Our reference: R/2022/2/A

Your reference: SSD-38600121

Subject: Advice on EIS - Alexandria Health Centre - 28-32 Bourke Road, Alexandria

Concept Plan / Level 06 - Courtyard

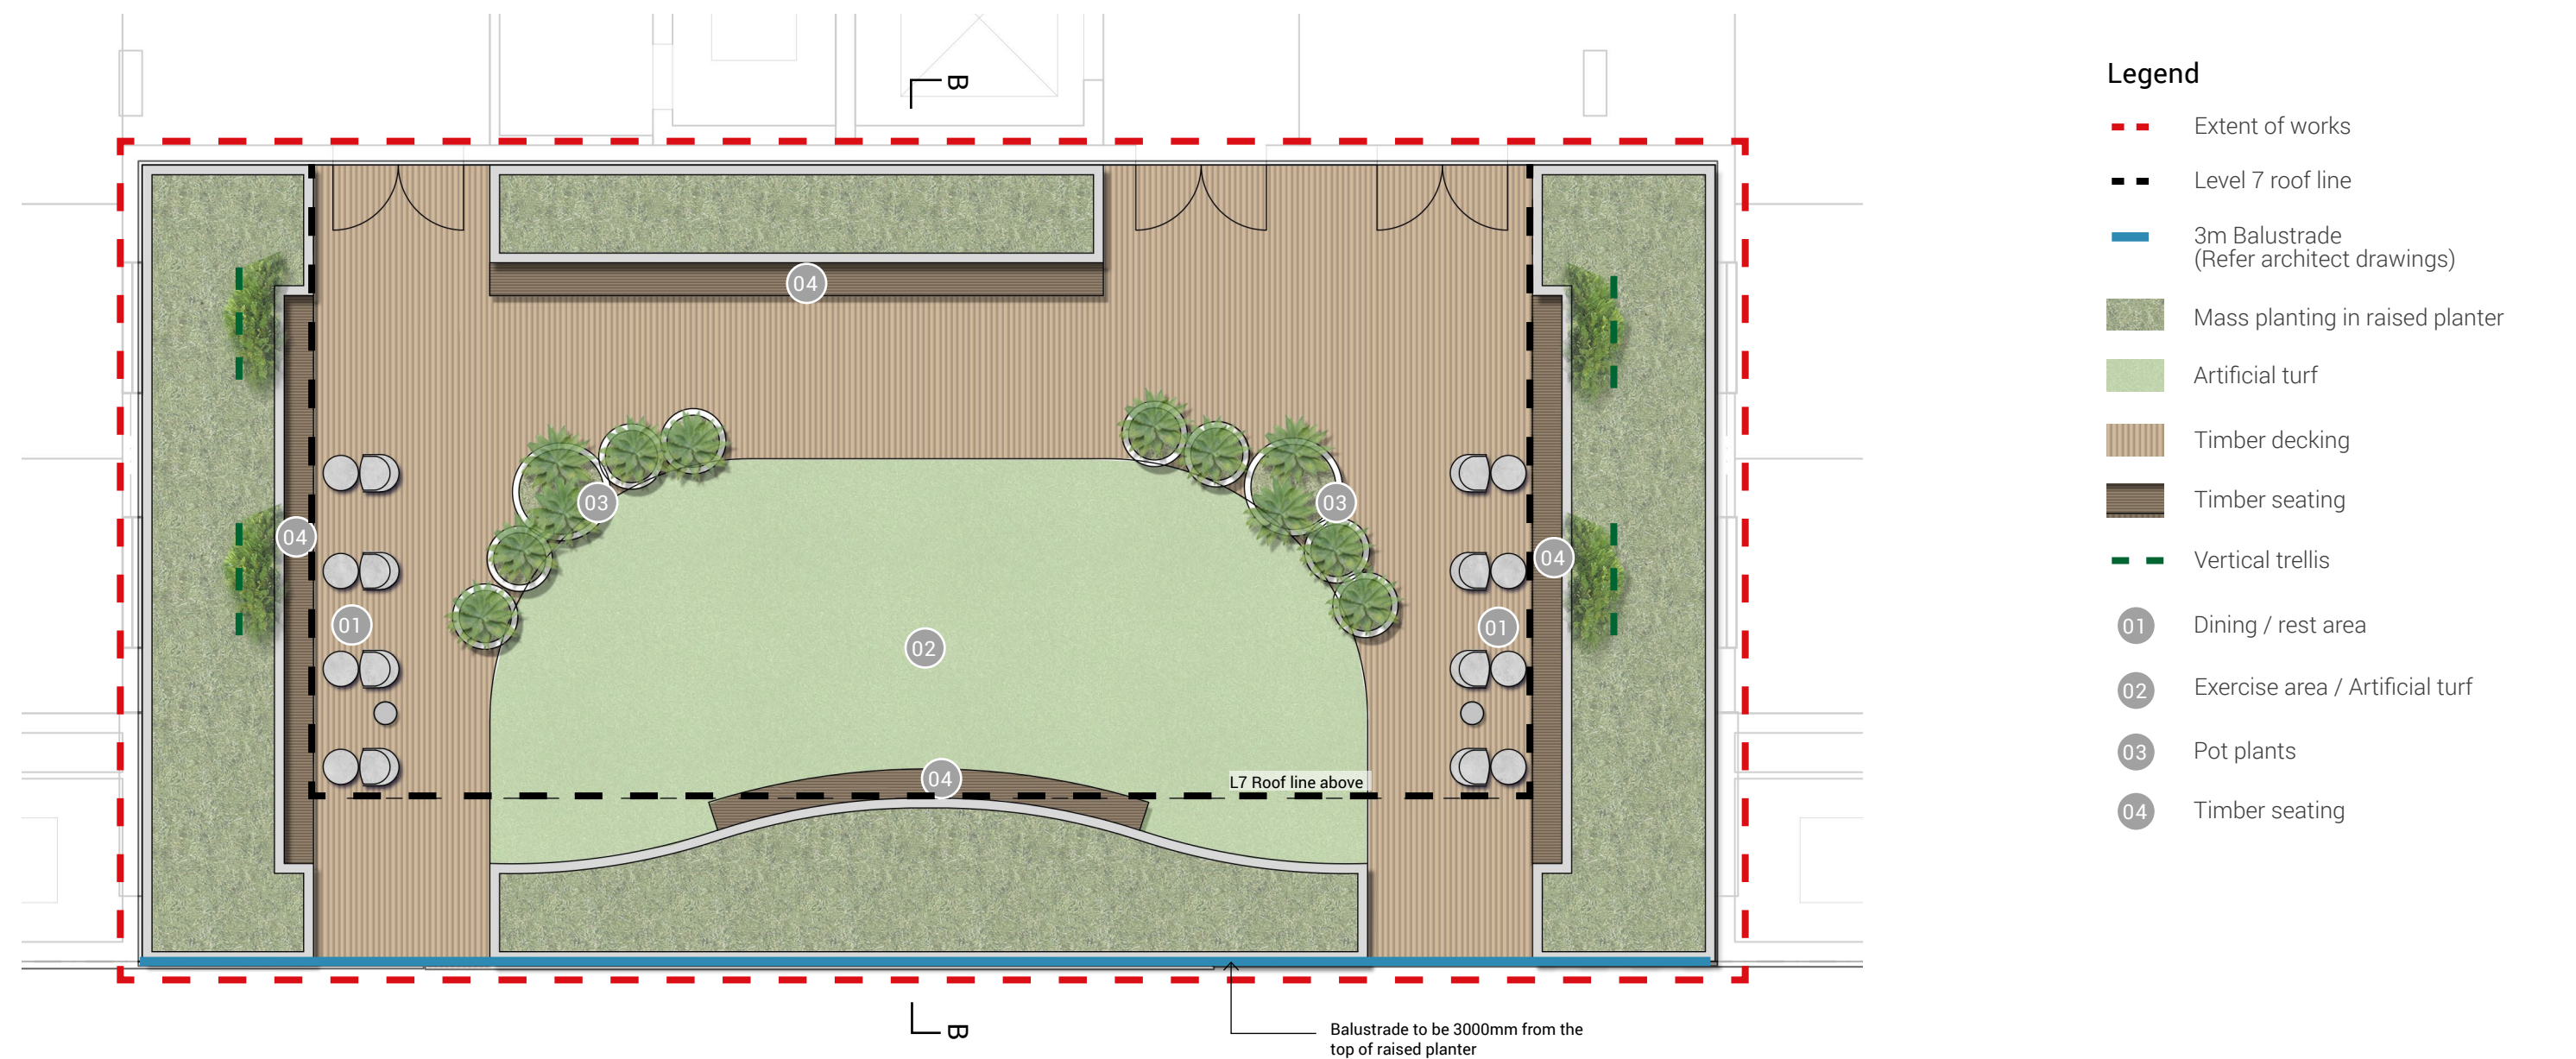
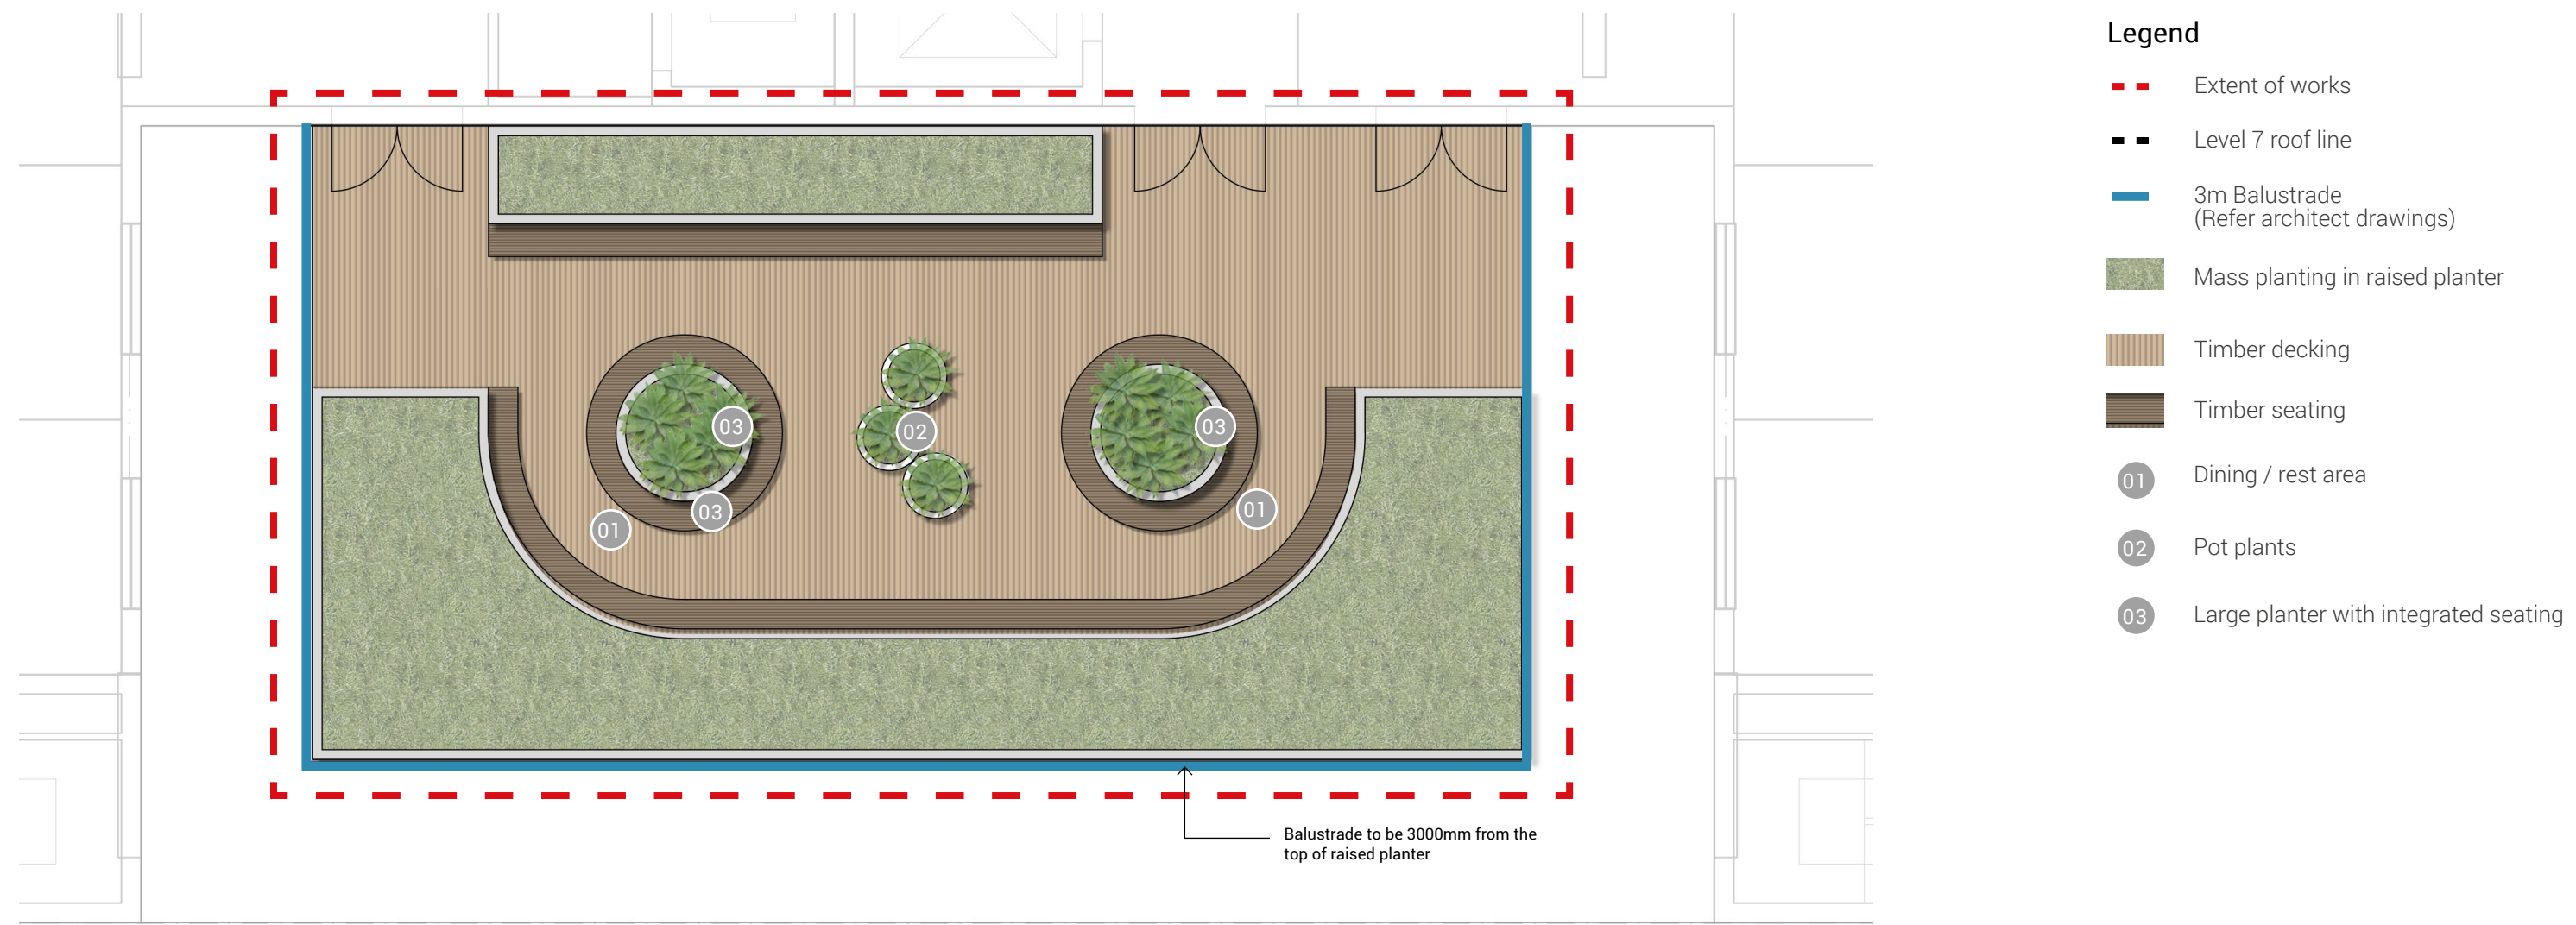
- Ground floor - shallow planters 450mm high located over the basement and for green walls on the western boundary
- Level 4 - narrow 1m depth perimeter planters on the western and southern edges
- Level 6 and 7 - east facing rooftop courtyards with seating areas, freestanding pots, 550mm depth planters and artificial turf

The rooftop areas include artificial turf surface finish. Recent research findings by Dr Sebastian Pfautsch show that in warmer months, unshaded artificial turf installed in schools and playgrounds recorded 60-100°C surface temperatures. This synthetic surface finish becomes a heat trap, can cause serious burns, and result in unusable outdoor spaces. Further, the plastic finish of synthetic turf and its artificial nature does not contribute any biophilic and biodiversity outcomes, and is likely to end up in landfill in the future.

The City recommends a full review of surface finishes and limiting the use of synthetic surface materials (turf and modular timber decking) and allowing for natural surfaces and natural shade.

Indicative Street Section – Bourke Road (B), North Alexandria (excerpt from Draft DCP)

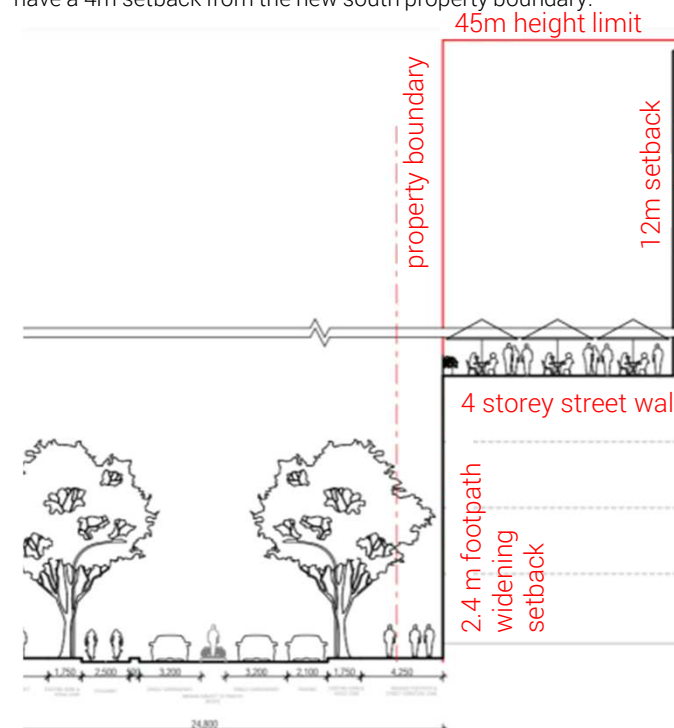
The proposed reference scheme does not follow the setbacks envisaged in the DCP. Instead, it proposes a 12 metre setback on the ground floor and above, with deep soil and landscaping within the front setback. The Urban Design report states that the 4 storey street wall is achieved through an architectural screen, which building users will pass under as they enter the building and the landscaped area would sit behind this screen.

The absence of providing the 4 storey street wall on Bourke Road risks the building not adequately relating to the adjacent future development along Bourke Road. The street wall plays an important role in defining the spatial structure of a place. It defines the 'space' of the street, provides visual cut off from the street to the taller building behind the setback, creates a consistent built form along the street by linking one building to another and minimises 'perceived' density by creating a continuous wall along the street with appropriate articulation. In addition, the street wall avoids the negative impact of exposed boundary walls for 12 metres in the view along the street and strengthen legibility by clearly indicating 'gaps' in the street wall where the cross streets and lanes are located.

The street wall is an important mechanism for defining space in an urban area and cannot be resolved through an architectural screen. The City does not support the proposed architectural screen and this should be removed from the concept proposal.

If the 4 storey street frontage height is not pursued, then the following issues must be resolved:

- The proposed lift at the front of the site on Bourke Road is not supported. This area is flood prone and is therefore a poor location for a lift. Further, the City considers these types of lifts to be a very poor way of providing equitable access for all people and this is particularly problematic given the use of the building as a hospital. As a minimum, the lift should be relocated to be inside the building. Alternatively, replacing the lift with a ramp system inside the building would provide a far superior outcome for future users of the site.
- The power supply kiosks must be relocated. They are currently located within the deep soil zone and in a flood prone part of the site.
- The deep soil zone must be increased (see Point 4 below) and the basement wall facing Bourke Road will need to be relocated.
- The architectural screen must be removed.

DEEP SOIL PLANTING / ZONE

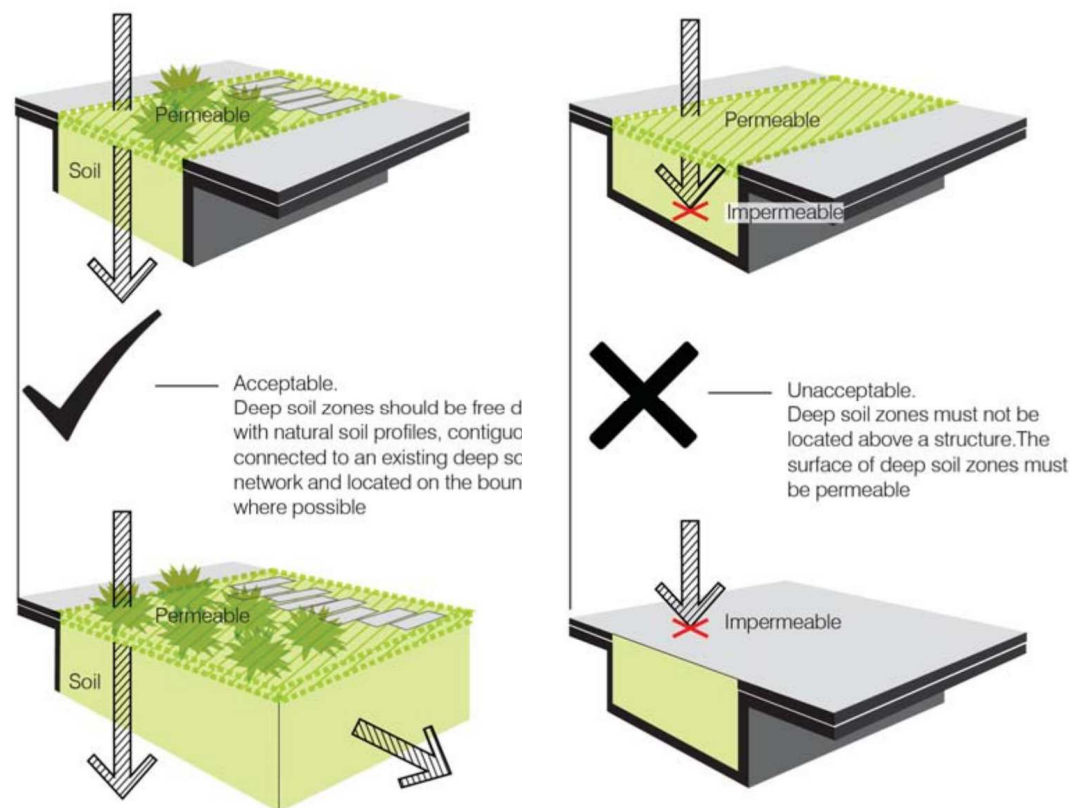
- The envelope plans do not locate deep soil.
- The reference scheme basement and ground floor plans indicate a deep soil zone on the Bourke Road frontage that is encumbered by several structures. Substations are not supported in deep soil zones, nor in flood prone land, and allowance should be made for chamber substations within the building.

The envelope plan is to be amended locating a minimum of 10% deep soil and provide an alternate location for substations. Once this is updated, the envelope plans should be stamped and a concept condition imposed that ensures that 10% of the total site area (after dedication) achieves deep soil in accordance with the SDCP 2012 and a plan must be submitted demonstrating this prior to the issue of a design competition brief/ detailed development application.
